EL PASO COUNTY STORMWATER MANAGEMENT PLAN CHECKLIST

SP229

Revised: October 2021

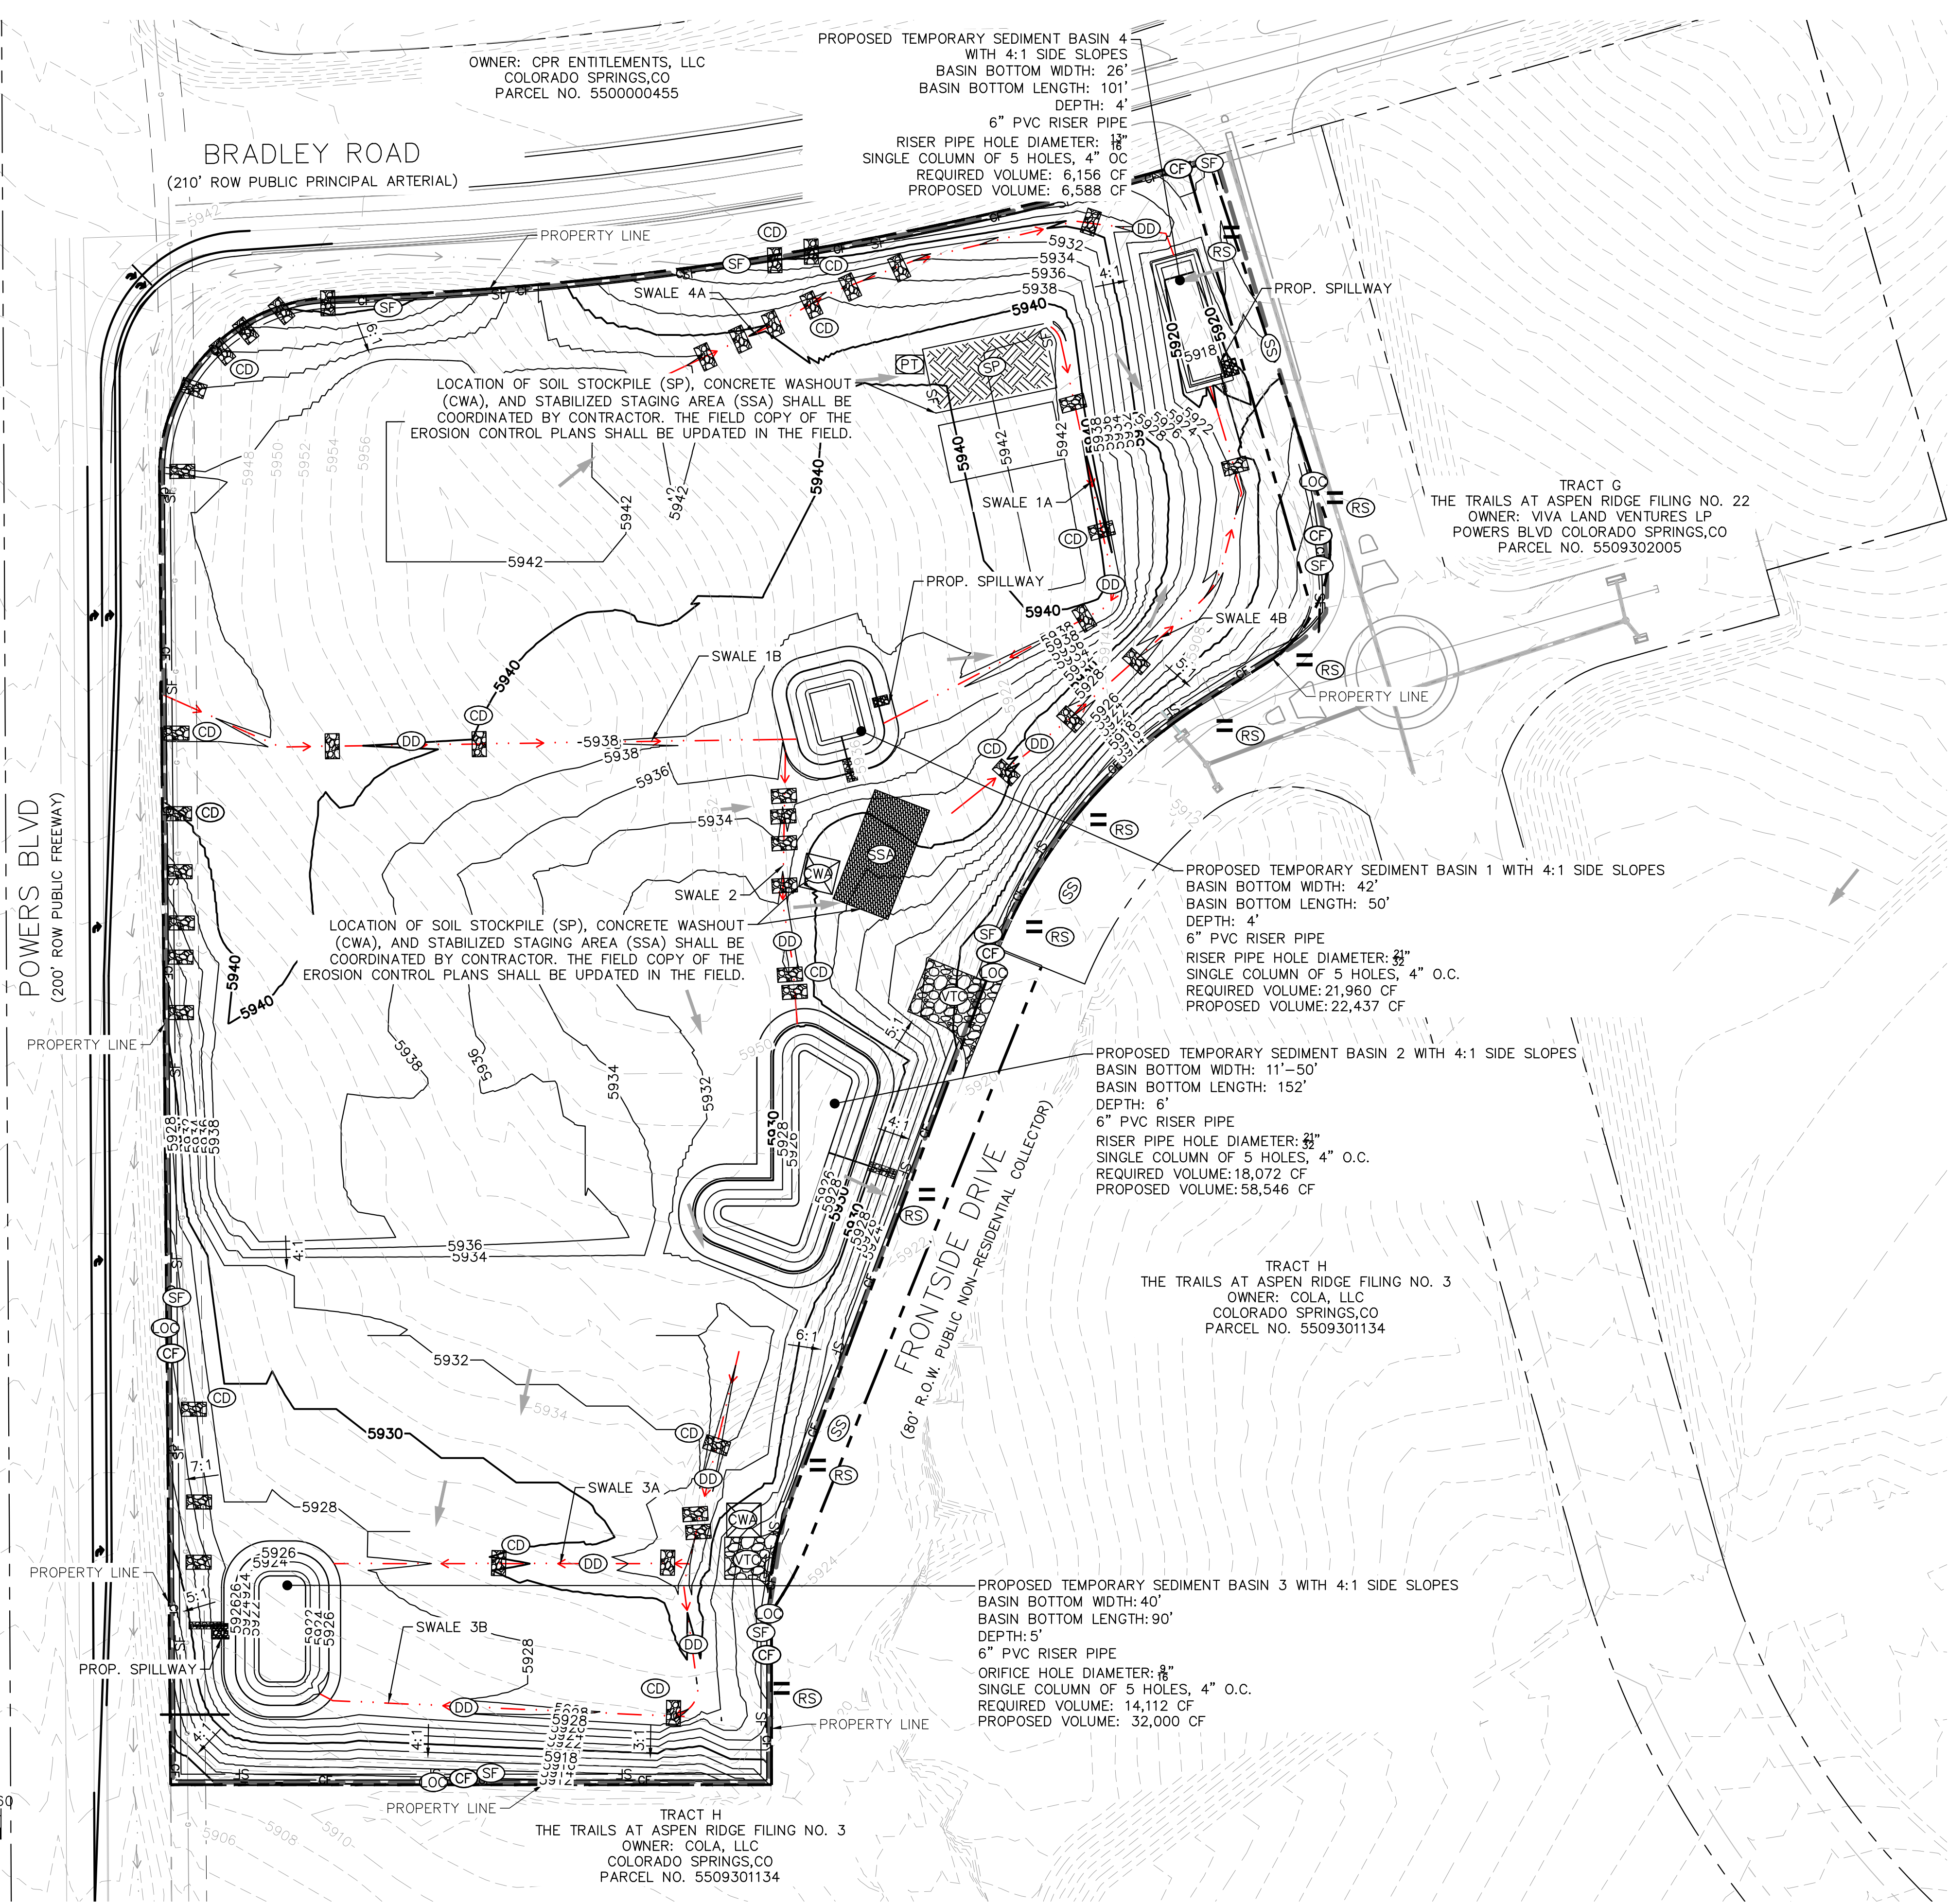
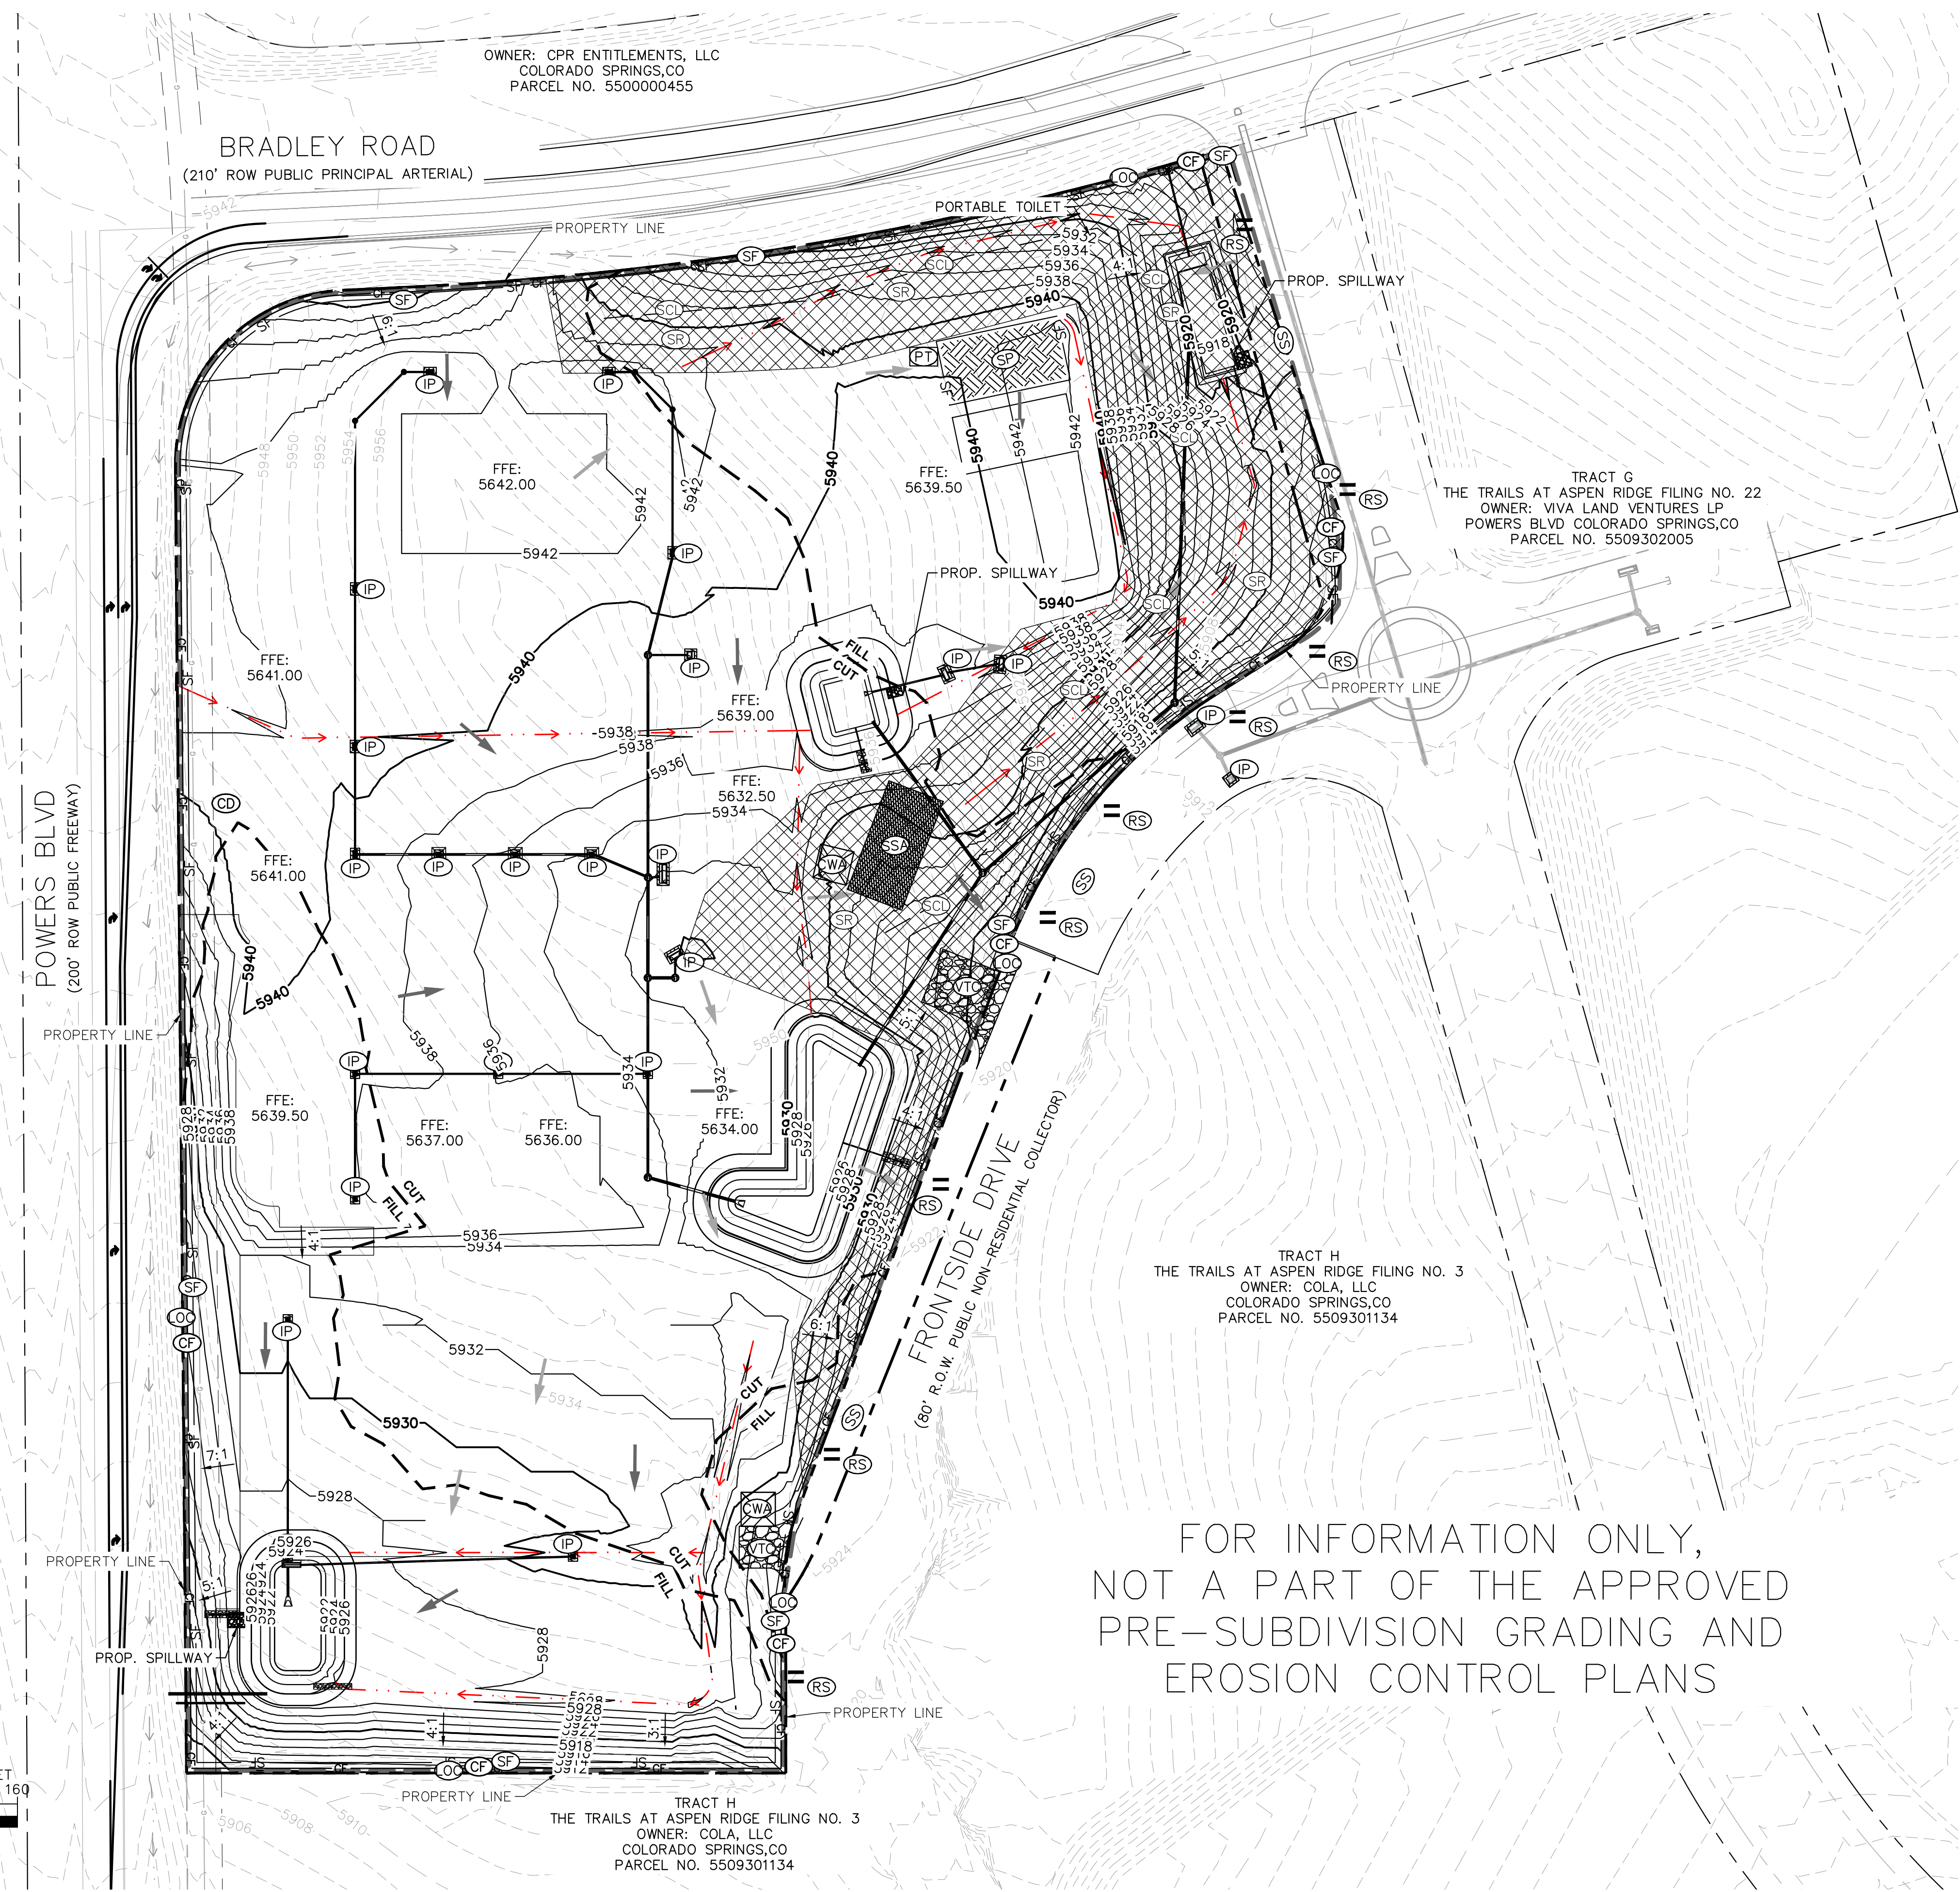
Applicant	EPC
17	SWMP Map to include:		
17a	construction site boundaries		Y
17b	flow arrows to depict stormwater flow directions		Y
17c	all areas of disturbance		Y
17d	areas of cut and fill		N
17e	areas used for storage of building materials, soils (stockpiles) or wastes		Y
17f	location of any dedicated asphalt / concrete batch plants		Y
17g	location of all structural control measures		Y
17h	location of all non-structural control measures		Y
17i	springs, streams, wetlands and other surface waters, including areas that require maintenance of pre-existing vegetation within 50 feet of a receiving water		Y
18	Narrative description of all structural control measures to be used. Modifications to EPC standard control measures must meet or exceed County-approved details		Y
19	Description of all non-structural control measures to be used including seeding, mulching, protection of existing vegetation, site watering, sod placement, etc.		Y
